Address: 20 Ullswater Close Dewsbury Wf12 7pn

Application number: 2024/90137	
What is the application for?:	Outline application for erection of 1 dwelling
Address of the site or building:	adj, 18, Ullswater Close, Dewsbury, WF12 7PN
Postcode:	WF12 7PN

Type of comment: An objection	
Do you wish your comments to be published on the website anonymously?	No

Proposed Site Plan

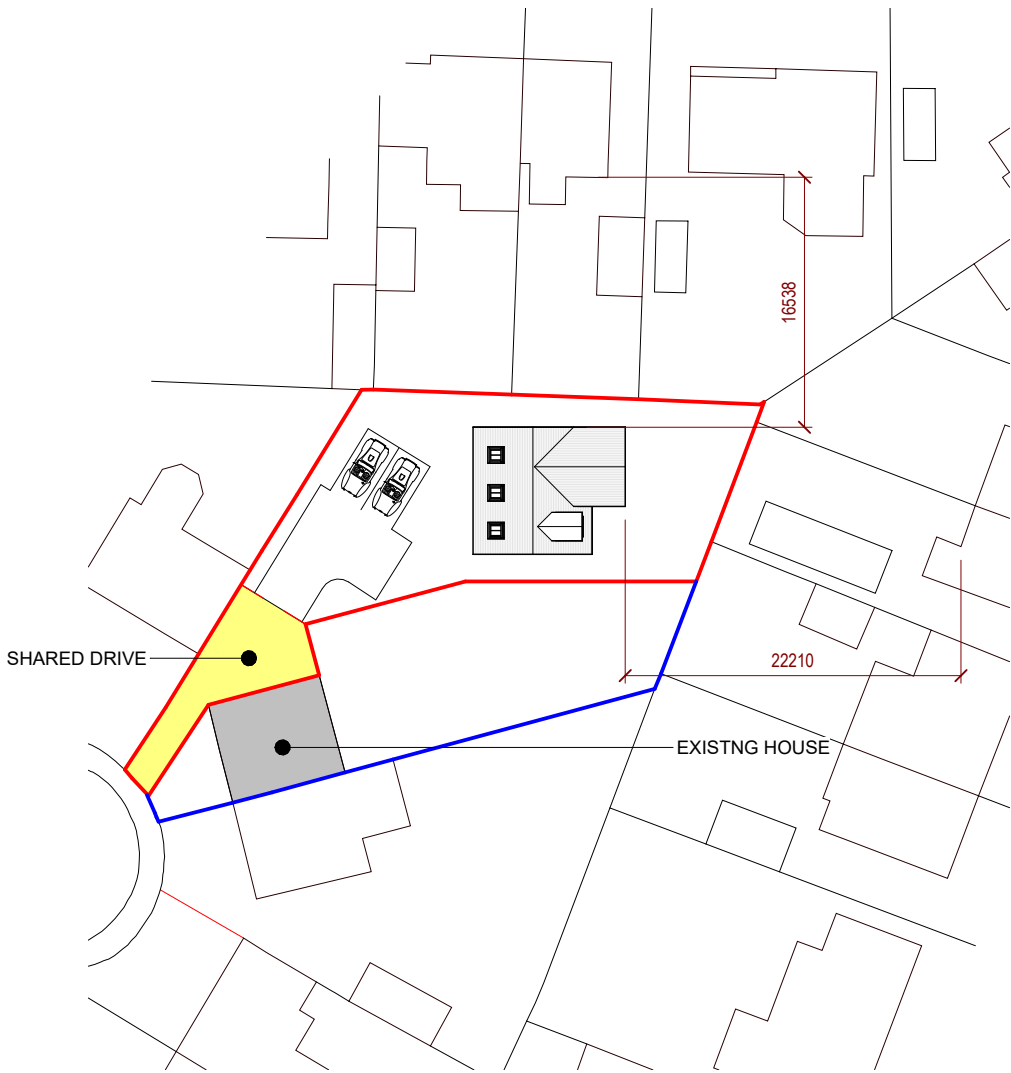
A big concern for me is the safety risk this proposal presents as neither ambulance or fire vehicles will be able to access the new building, as the gap between the houses is so small This would also cause a fire risk to the surrounding houses.

Access to this new build would be via a shared driveway with no.18 and this access point would be firmly up against my property no.20.

The existing driveway is already very narrow and the current owner already struggles to get a small car up and down it easily. Therefore, if the existing drive was made into a shared access point, the problem would be exacerbated, To add to this, the existing access gap between the external wall of my kitchen/garage( at no.20) and the house wall of no. 18 is very already minimal.

The proposed shared drive means numerous cars will be trying to get down the drive right next to my house and also this is under one of our bedroom windows which will cause noise and pollution disturbance to me and my family.

The new drive/access also has a turning point next to my garden fence/patio area/boundary. This will cause also disturbance from noise and also car pollution in an area where we eat in Summer as a family.

The cul de sac already has a number of cars on it and as this will be a shared drive there will be no parking area for the existing property no'18. This will impact on traffic on Ullswater close and is a safety risk.
